**PROJECT APPLICATION MP_08_0093 - RESPONSE TO ISSUES
DARLING WALK, DARLING HARBOUR**

Following the exhibition of the Project Application MP_08_0093 for Public Domain Works at Darling Walk, Darling Harbour, on behalf of Lend Lease Development, JBA Urban Planning Consultants has prepared this response to respond to the issues raised during the public consultation, describe the proposed revisions to the development and provide a revised Statement of Commitments.

KEY

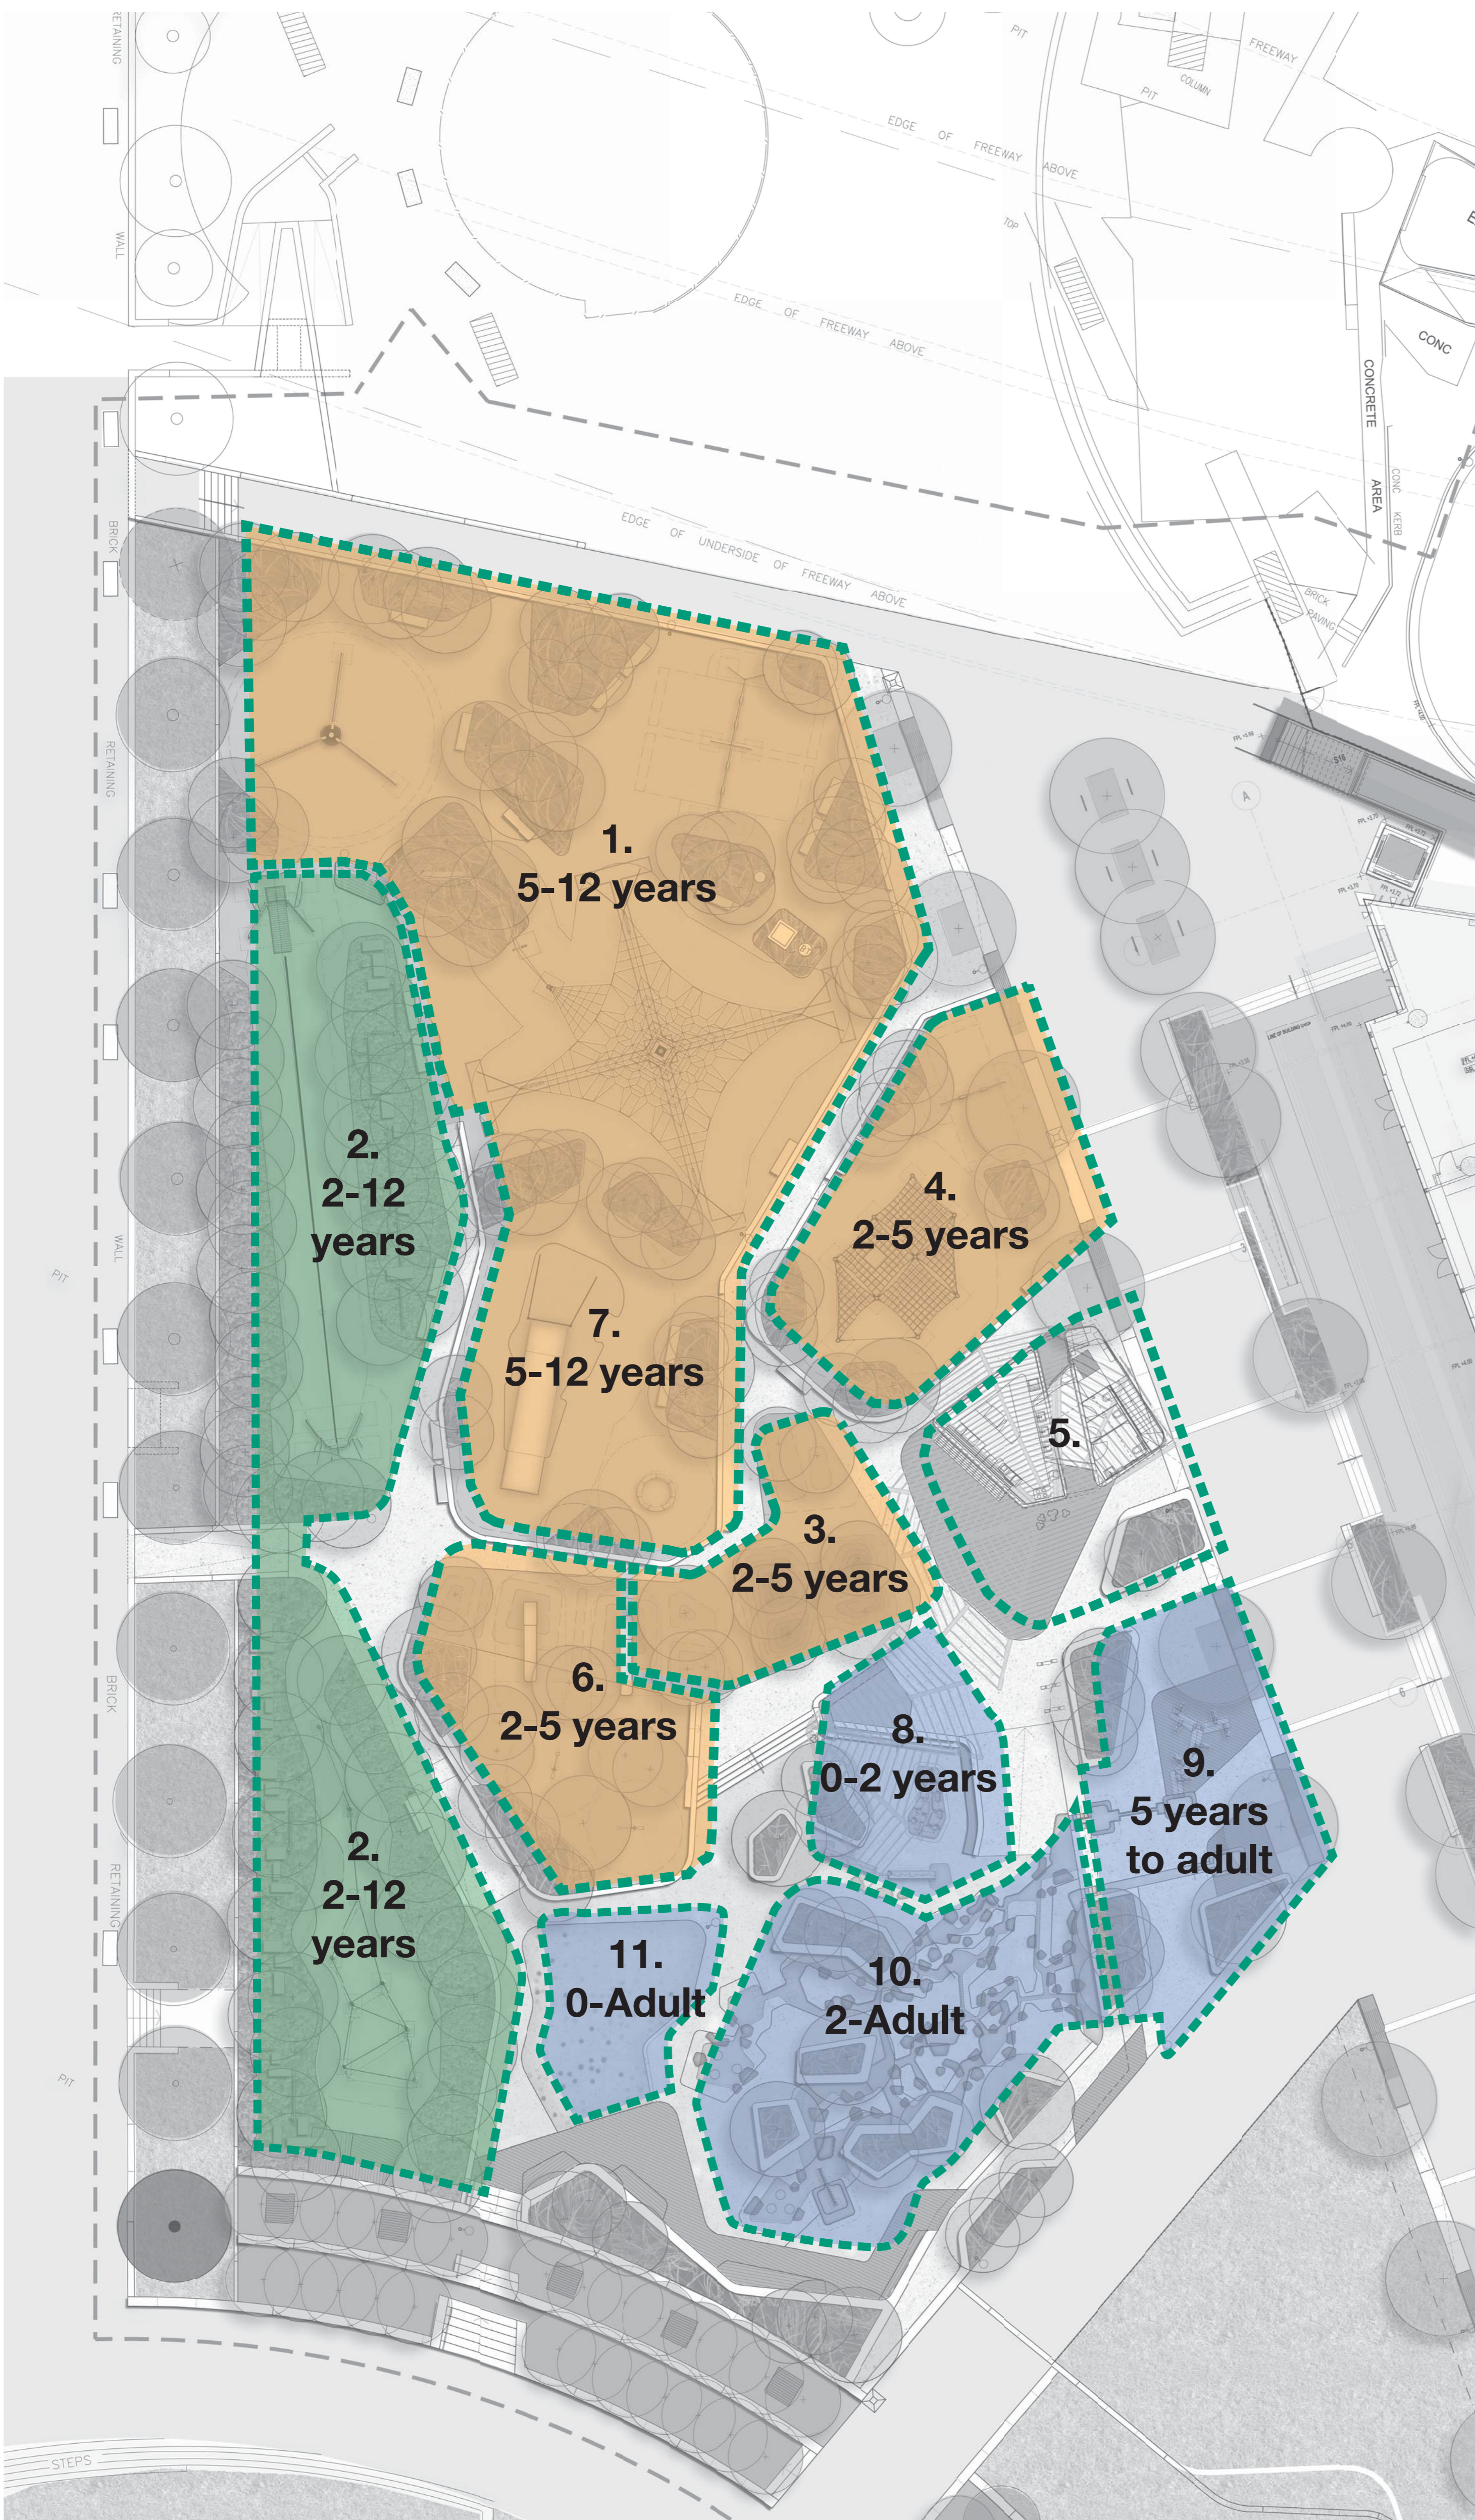
Separate to the public exhibition, Sydney Water requested that the location for some of the proposed play equipment be amended as it was sited over the Sydney Water stormwater channel and they considered the equipment not to be light-weight structure.

The design of the shade structures in the Children's Playground has been further refined due to structural load issues.

The angle and length of the shade structures has been altered, and additional trees are to be positioned to provide more shade over the seating area. In addition, due to structural load and engineering issues, the span originally proposed over the toilet building has been deleted.

In response, the layout of the play equipment in the north west corner of the Children's Playground has been amended to ensure that there is no play equipment over the stormwater channel.

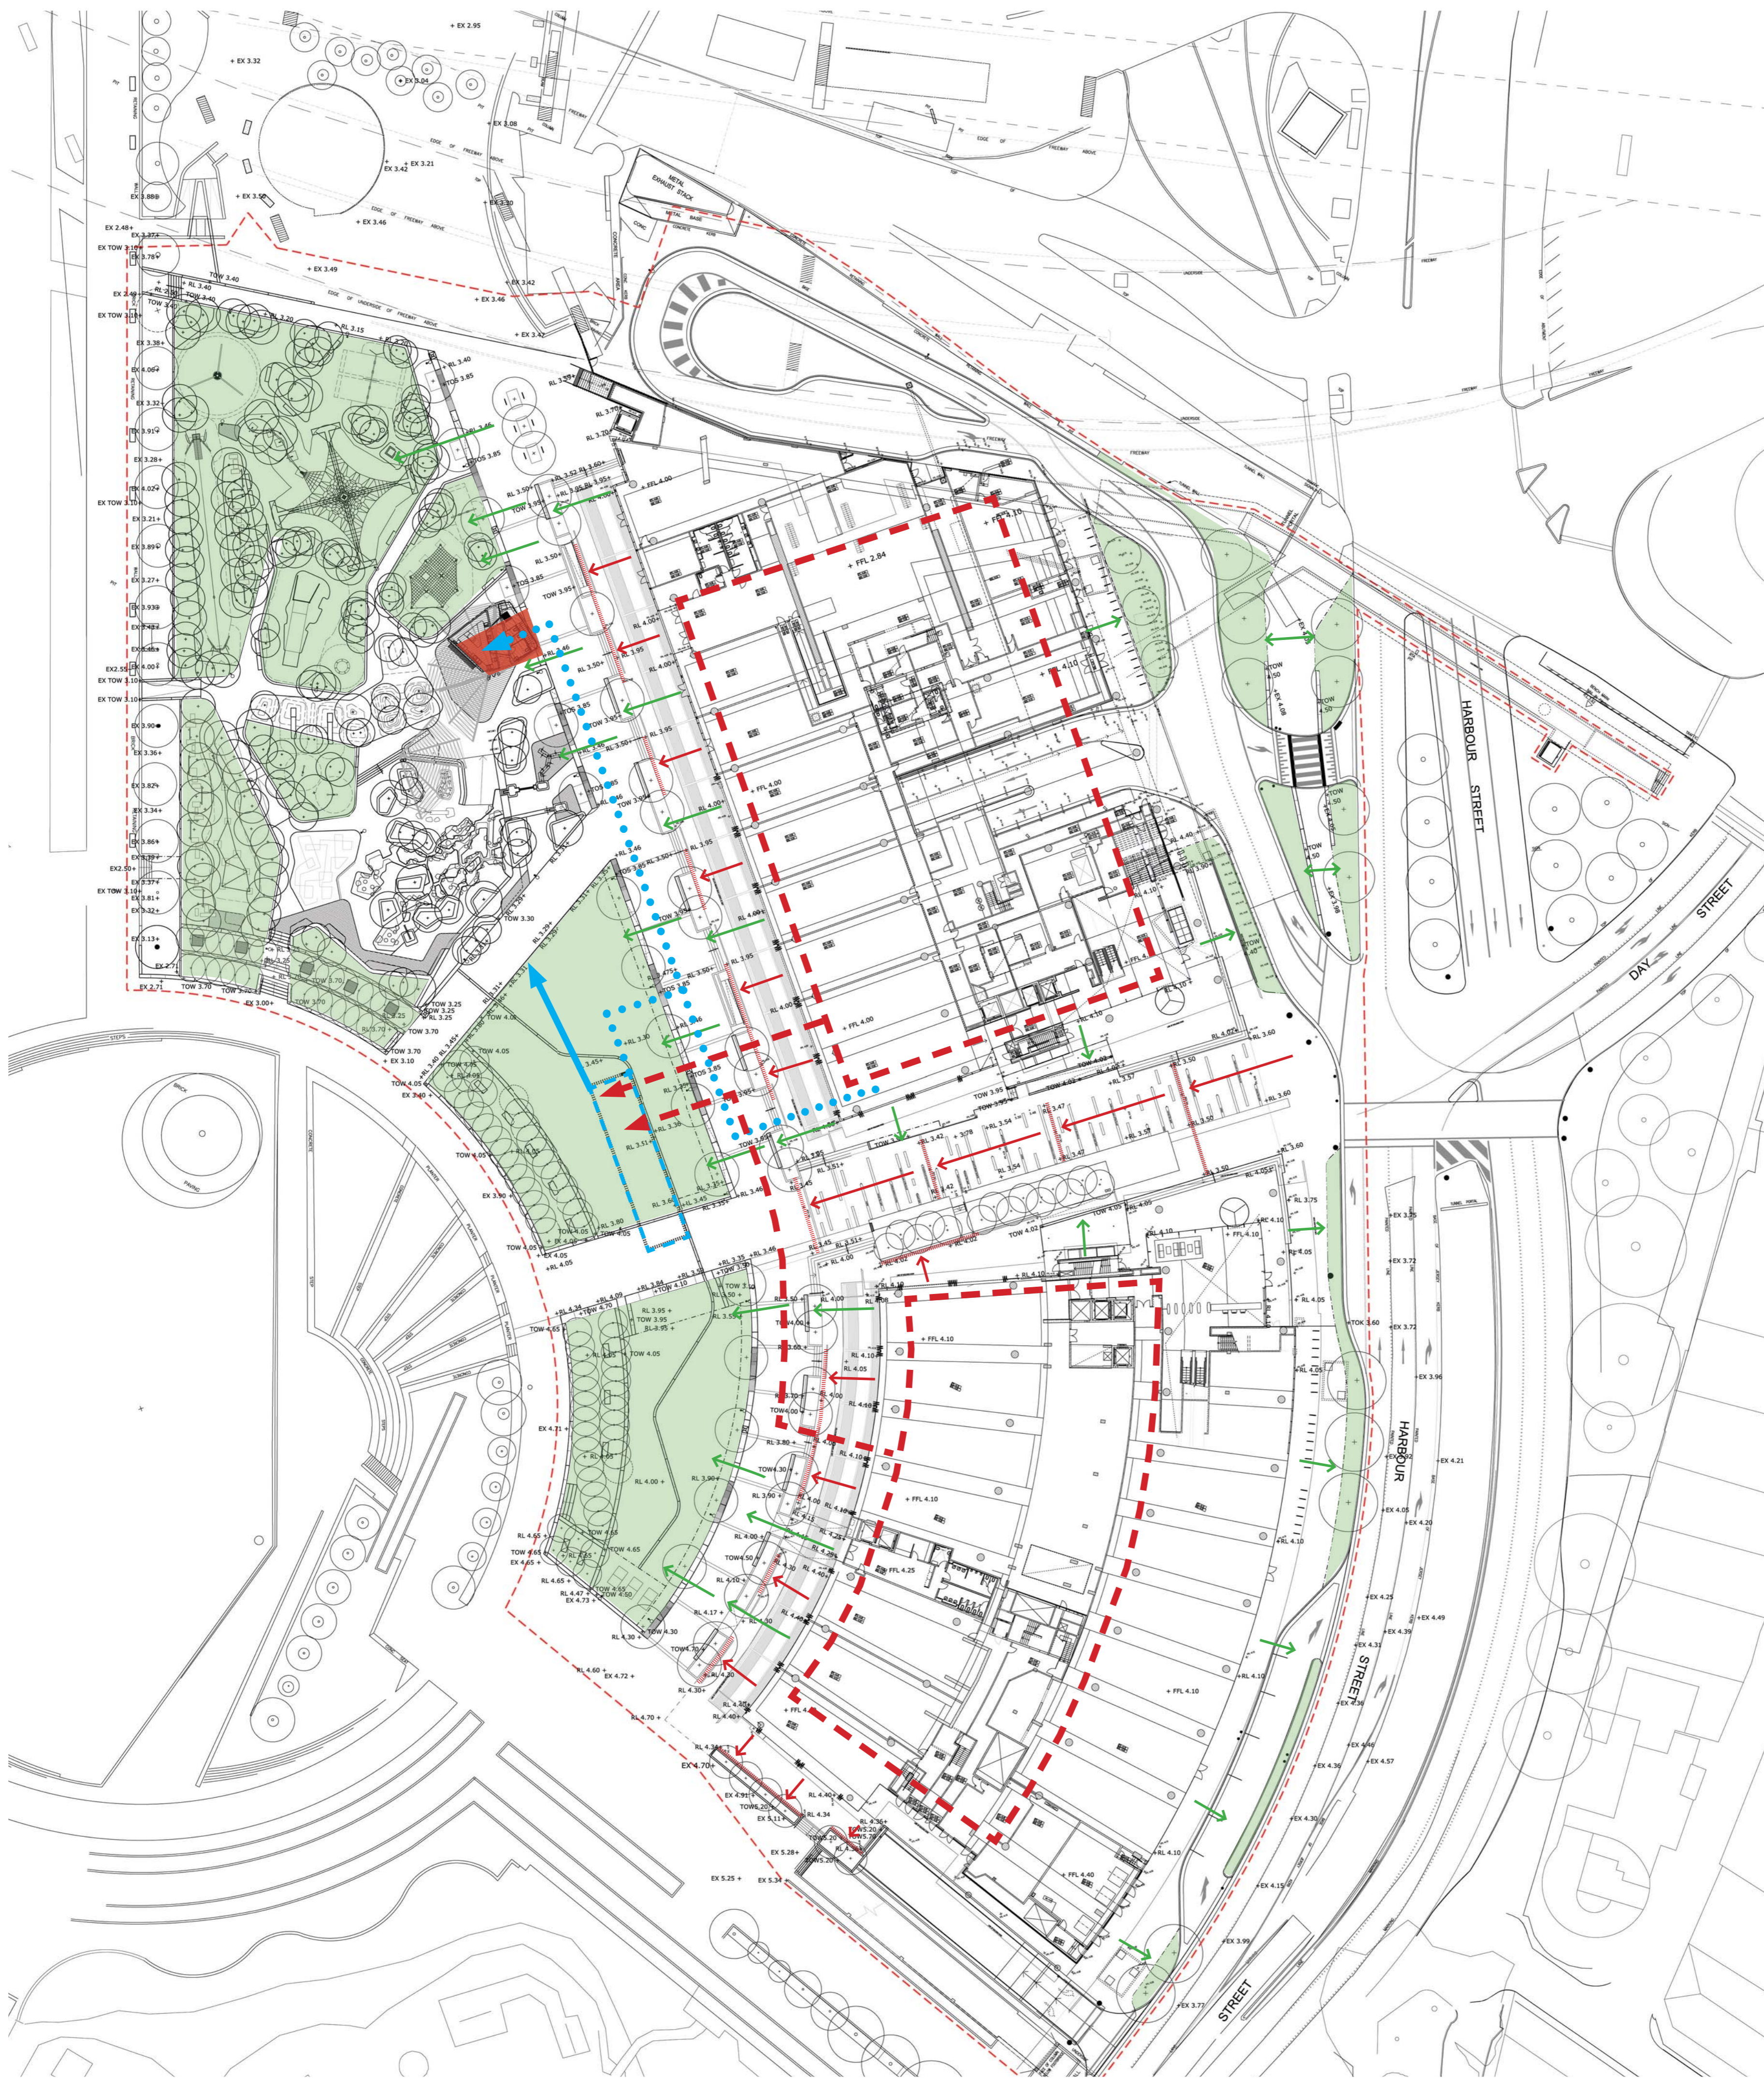
Request that any proposed removable safety grates be fitted with a lock, or designed such that they cannot be removed by children.	The inlet grate within the Civic Connector water feature will be mechanically fixed to the structure with concealed fixings.
Lighting	
Request details to ensure that the lighting conforms to Australian and Council Standards, with particular reference to road safety and pedestrian security.	The proposed lighting complies to Australian Standards S 4282 and AS/NZS 115.3.1 – 2005 Pedestrian Lighting. At 100% capacity light levels comply with Category P7 and at 50% dimmed capacity they comply with Category P1 (P8), the default lighting requirement of City of Sydney light design code.
Request that lighting be provided to the	Lighting is to be provided on the pedestrian

Comment	Response
Bathurst Street Pedestrian Bridge augmentation.	bridge to comply with Category P8 of Australian Standard AS/ NZS 1158.3.1- 2005 (refer to Attachment C).
Paving	
Request that consideration be given to finding a paver for the Harbour Street frontage that would match the rest of the footway i.e. outside the Chinese Gardens and Cockle Bay.	Lend Lease Development will seek to match the new pavers with the existing. However the Gertrudis Brown paver will be used if matching pavers are not able to be sourced. The Gertrudis Brown brick paver was chosen as a higher quality brick than the paver currently outside the Chinese Gardens and Cockle Bay, as they closely relate to the surrounding context and the existing pavers are in low supply. Should the Gertrudis Brown paver be used, an 'interwoven' interface between the surrounding brick and the Darling Walk brick will be provided to ensure that the two sets of pavers mix together.
